Application No.: 09DRB-70111 Project # 1004614
Proje	ect Name: Interstate Industrial Issues Unit 5
Ager	nt: High Mesa Consulting Group Phone No.:
IOIIO	request was approved on <u>3-25-09</u> by the DRB with delegation of signature(s) to the wing departments. STANDING SIGNATURES COMMENTS TO BE ADDRESSED
	TRANSPORTATION: SEE DEB comments from Transp. data) 3/2
	UTILITIES:
	CITY ENGINEER / AMAFCA:
	PARKS / CIP:
	PLANNING (Last to sign): Receive EPC Planners approval
	Planning must record this plat. Please submit the following items: -The original plat and a mylar copy for the County Clerk. -Tax certificate from the County Treasurer. -Recording fee (checks payable to the County Clerk). RECORDED DATE: -Tax printout from the County Assessor.

DEVELOPMENT REVIEW BOARD - SPEED MEMO

SITE PLAN FOR BUILDING PERMIT

Project #1004614, Health South expansion and improvements

SITE PLAN
1" = 40'

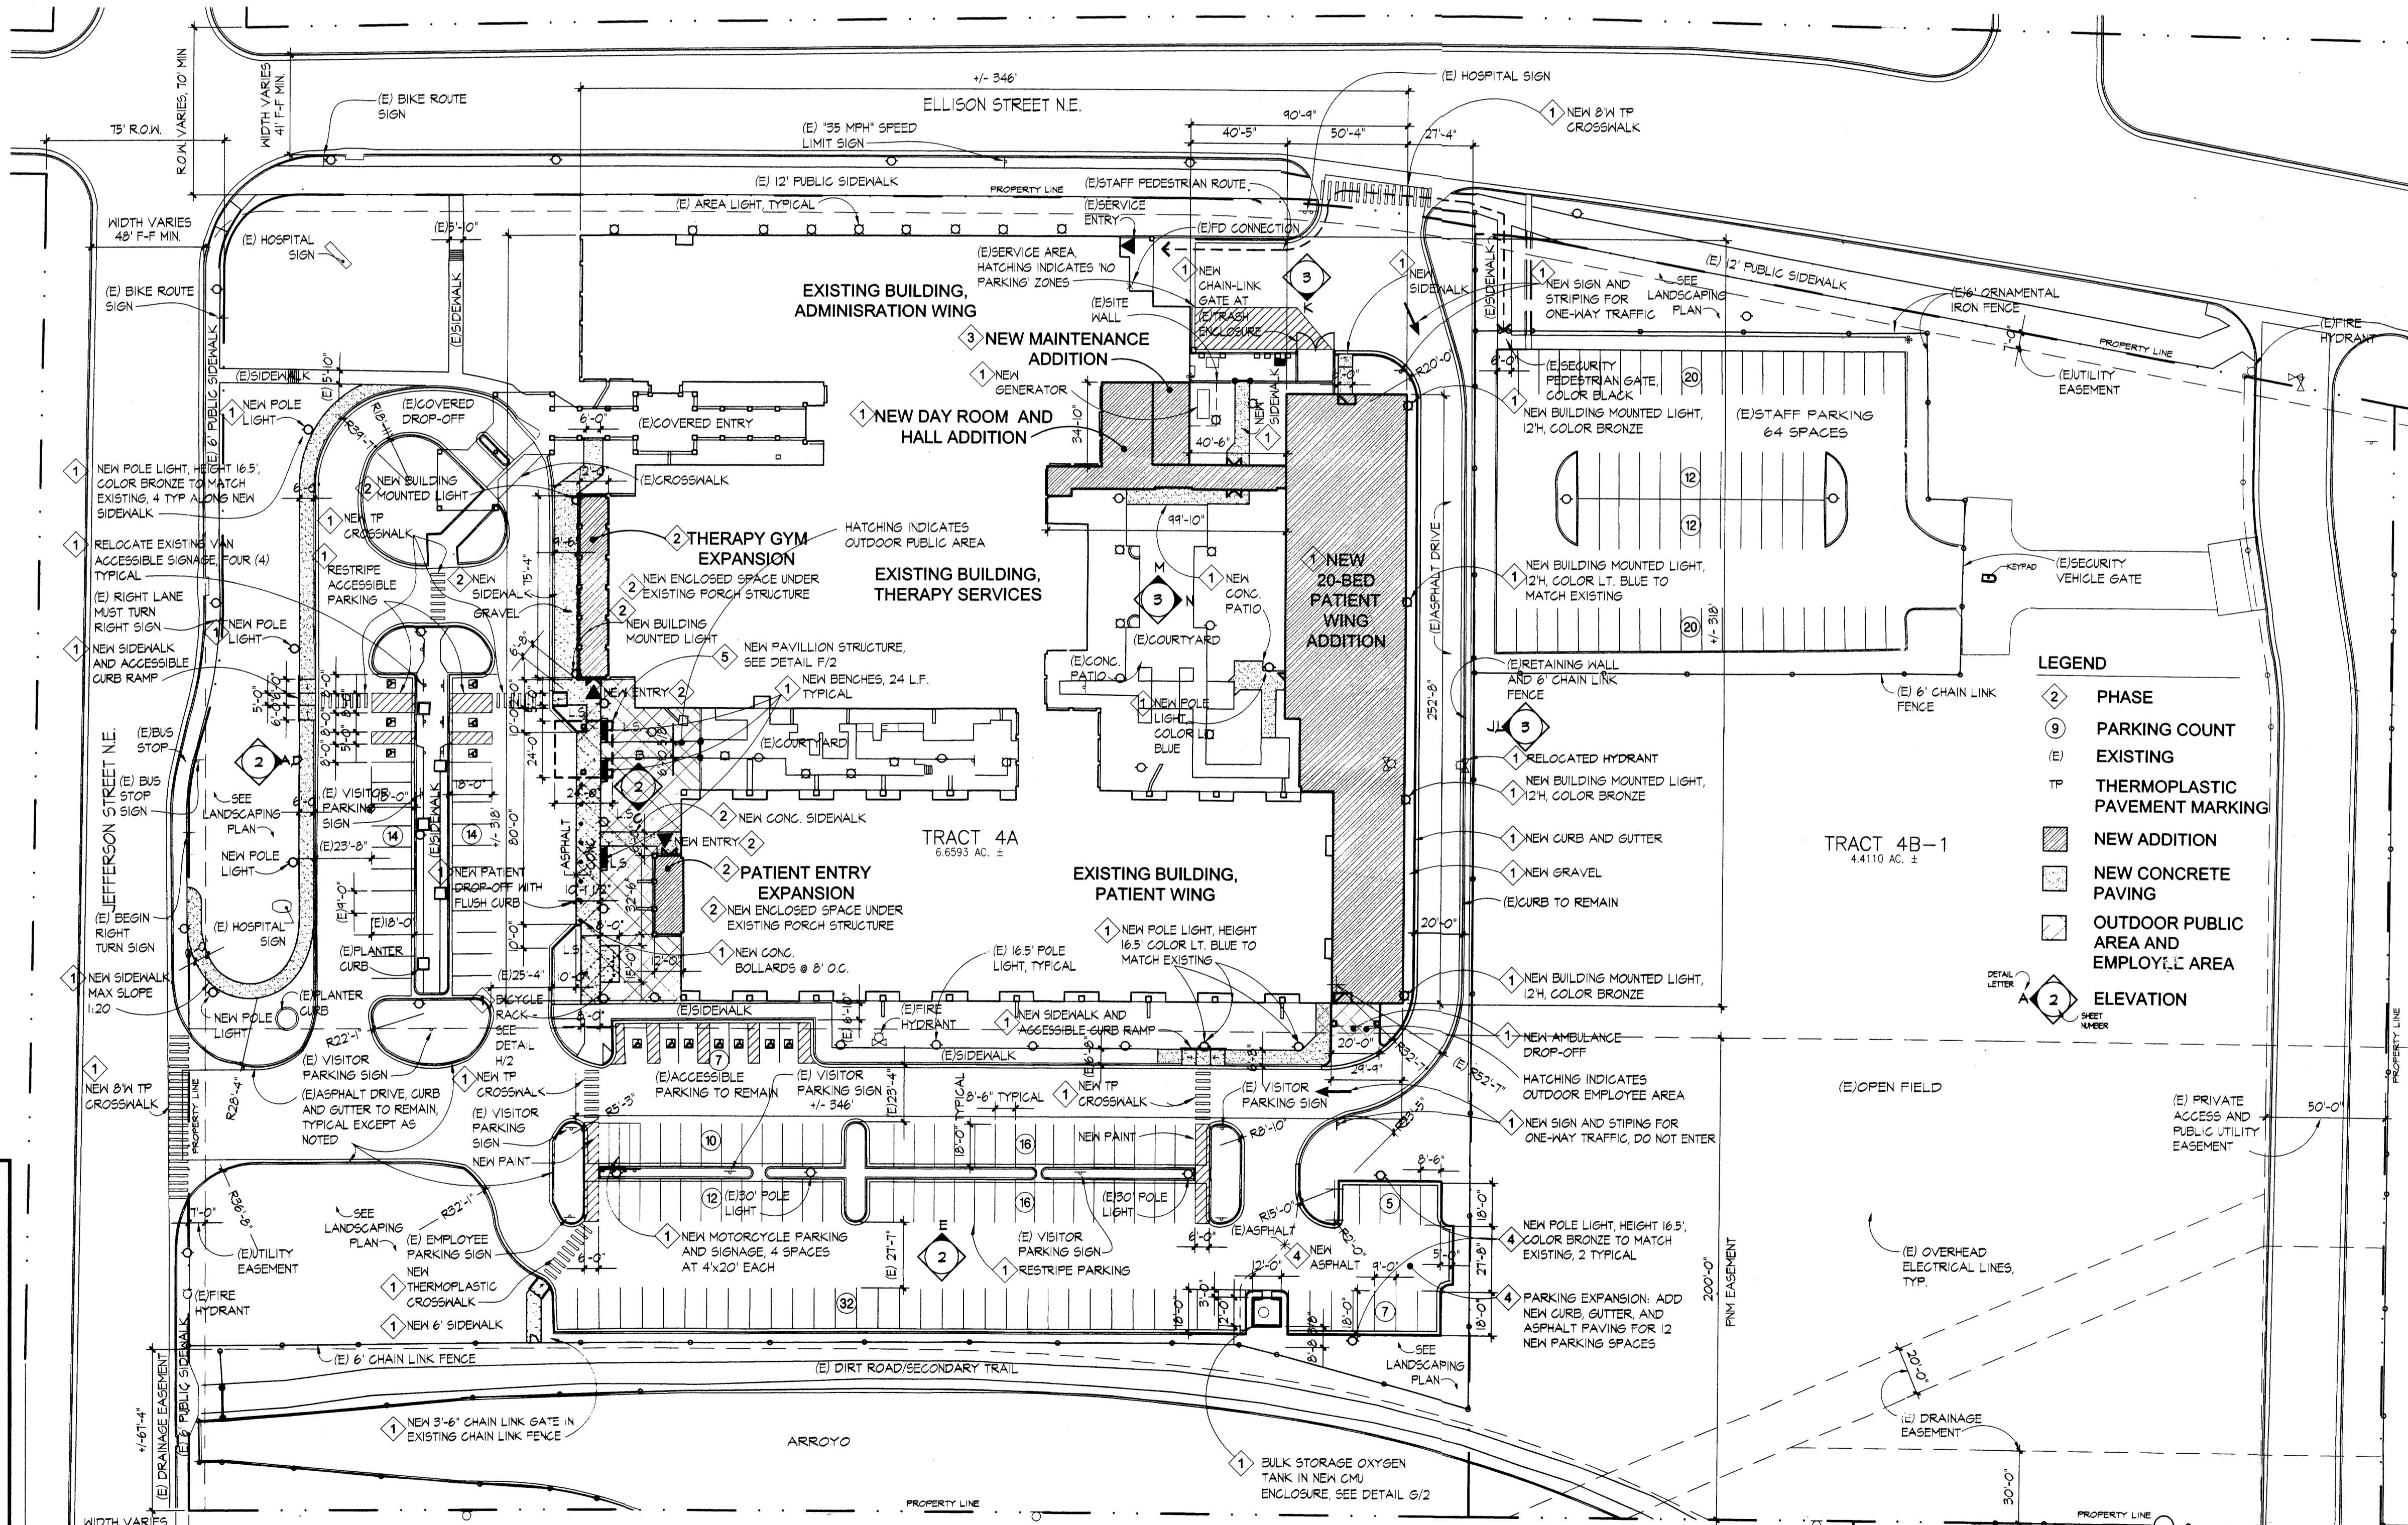
Provide an exhibit showing the location of sidewalk and defining the distance from face of curb to the property line. Right of way dedication may be required.

Show all ramps, both existing and proposed.

Clearly define the ADA accessible pathway from the proposed handicapped parking spaces; additional ramps may be required.

Provide a detail for all proposed wheelchair ramps; define the maximum slope.

SHEET TITLE
LANDSCAPING DETAILS AREA 3

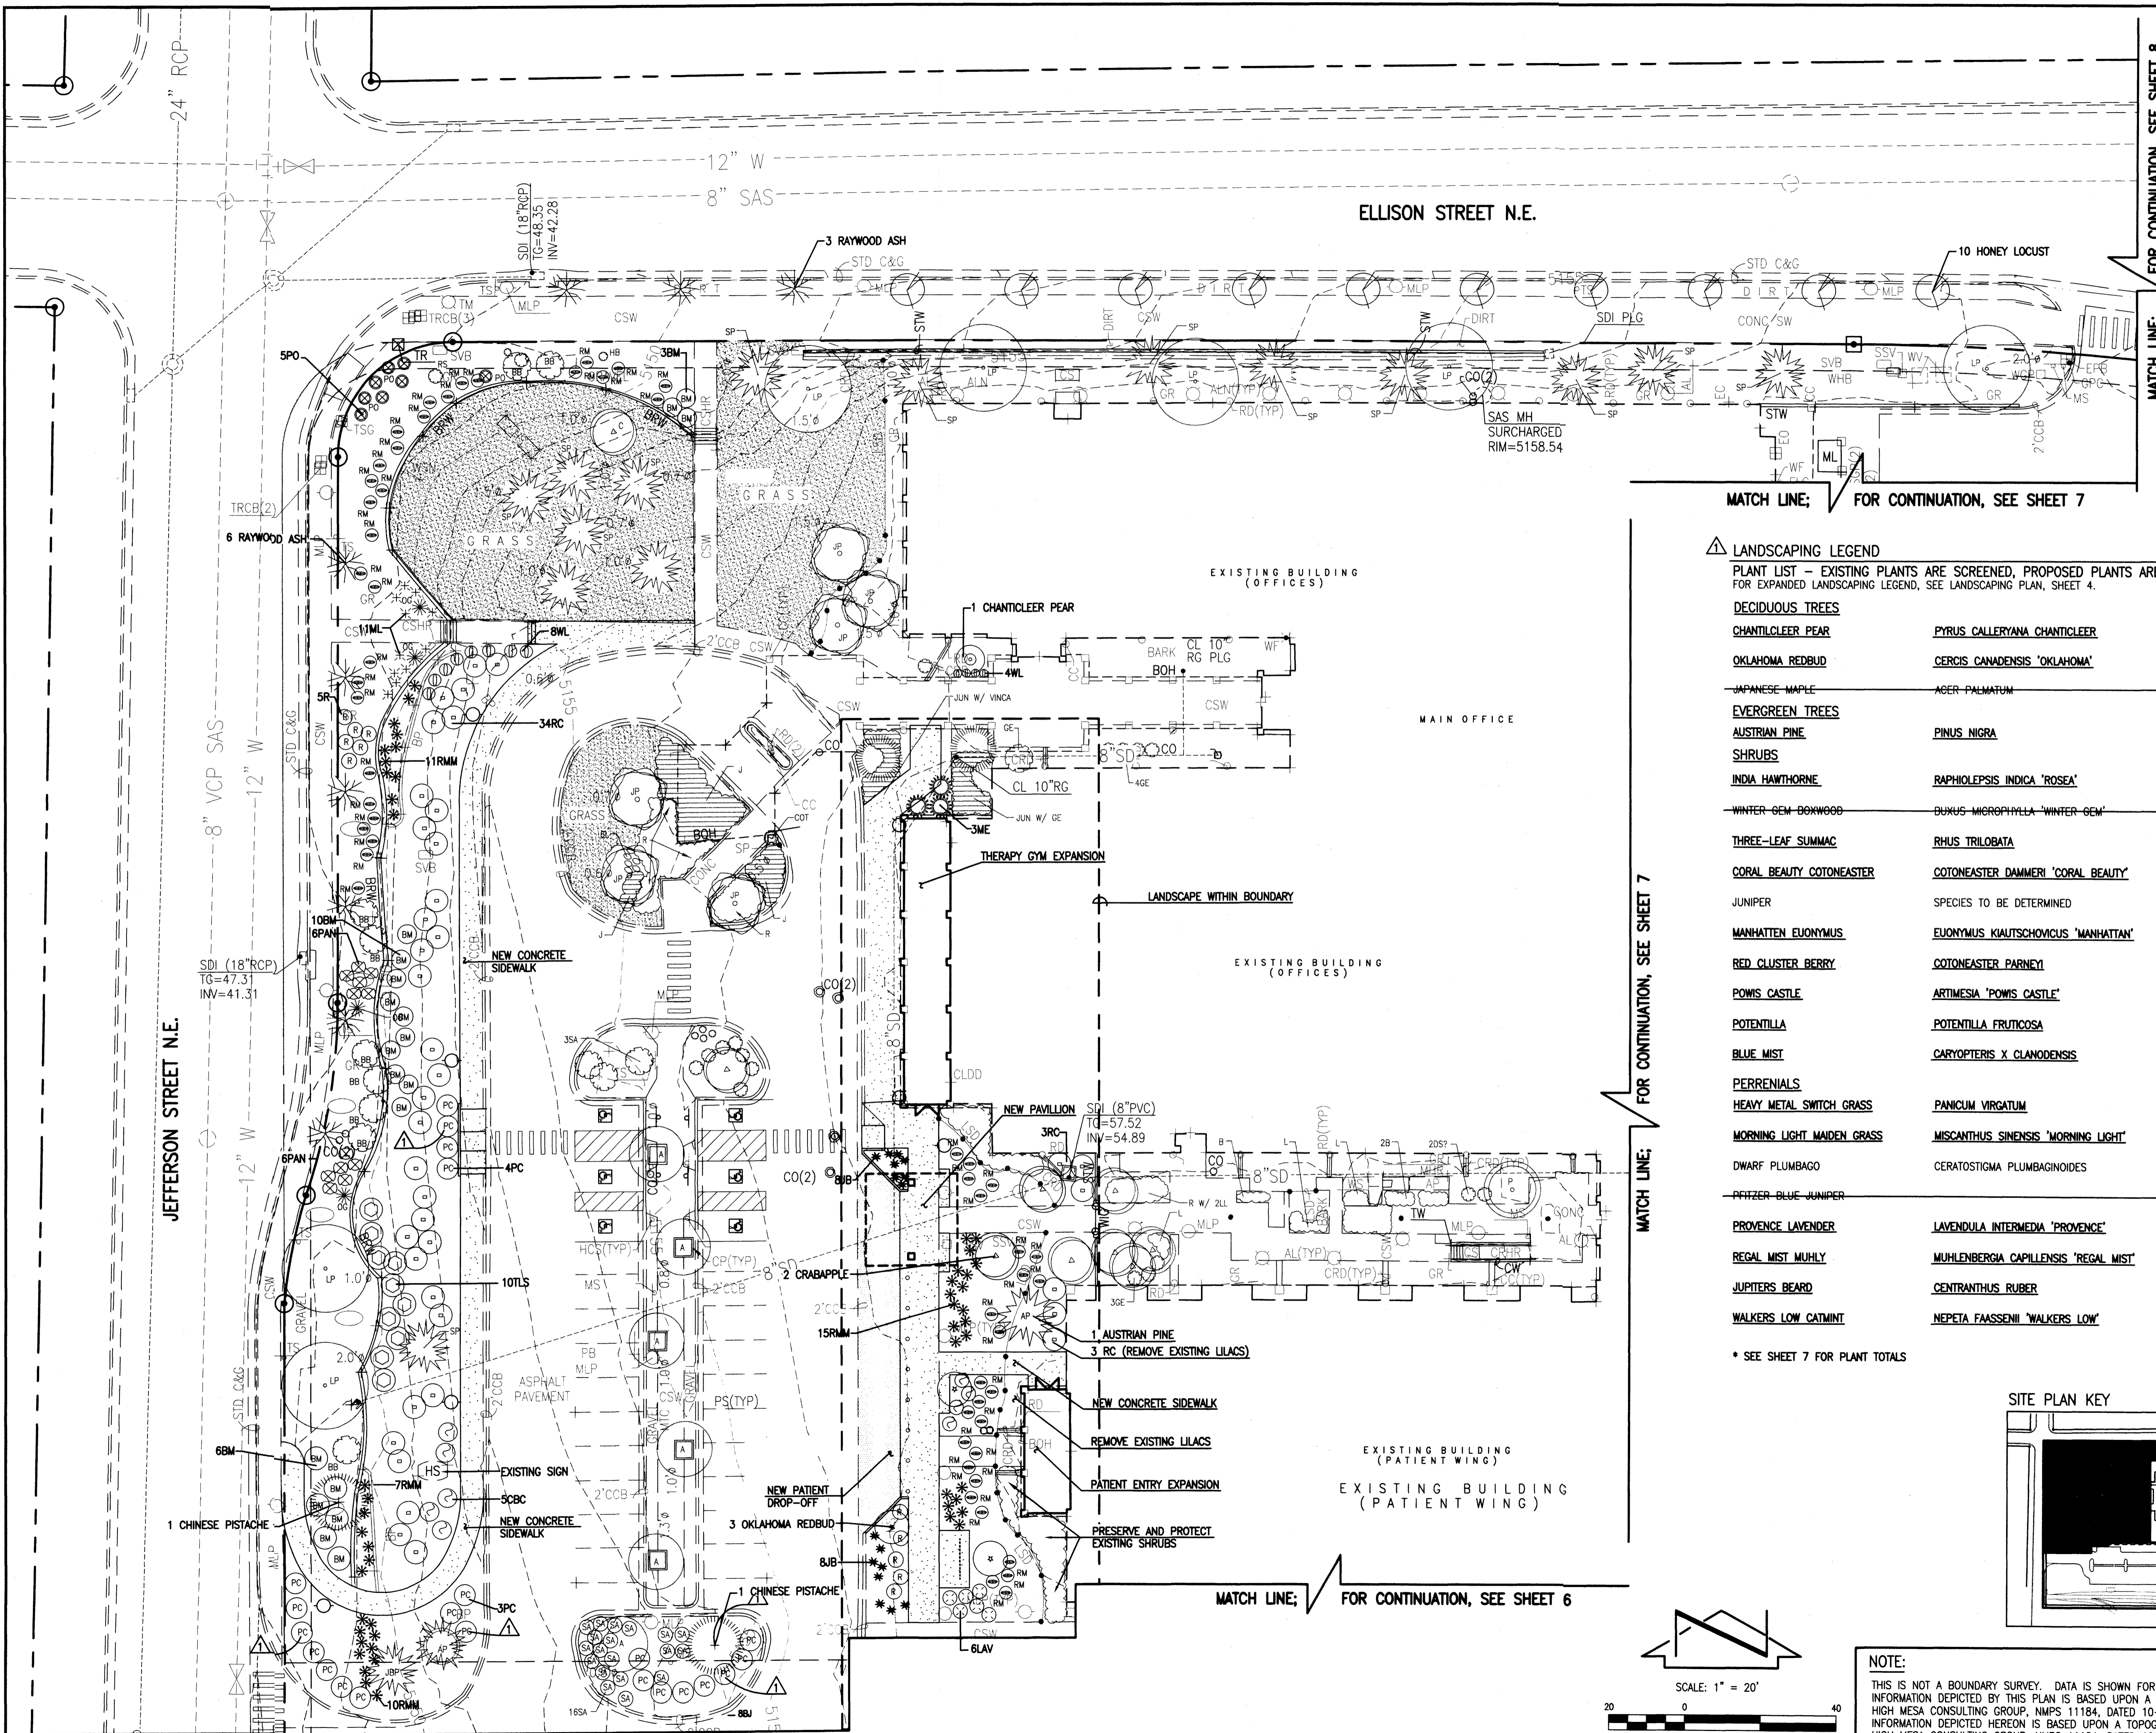
Condition 9B: Landscape Sheet 4 shows, in the left hand column, Raywood Ash as a new tree. Landscape Sheet 5 shows 6 new Raywood Ash along Jefferson St. To meet this condition, a non-allergenic tree is needed to replace the Ash trees.

Condition 9C- Note: The symbol used for the Chinese Pistache (CP) needs to be bolded. Otherwise, it looks like the symbol for Apple tree.

Condition 10B: The symbol P needs to be added to the legend on Landscape Sheet 5. There are pear trees shown on Landscape Sheet 5.
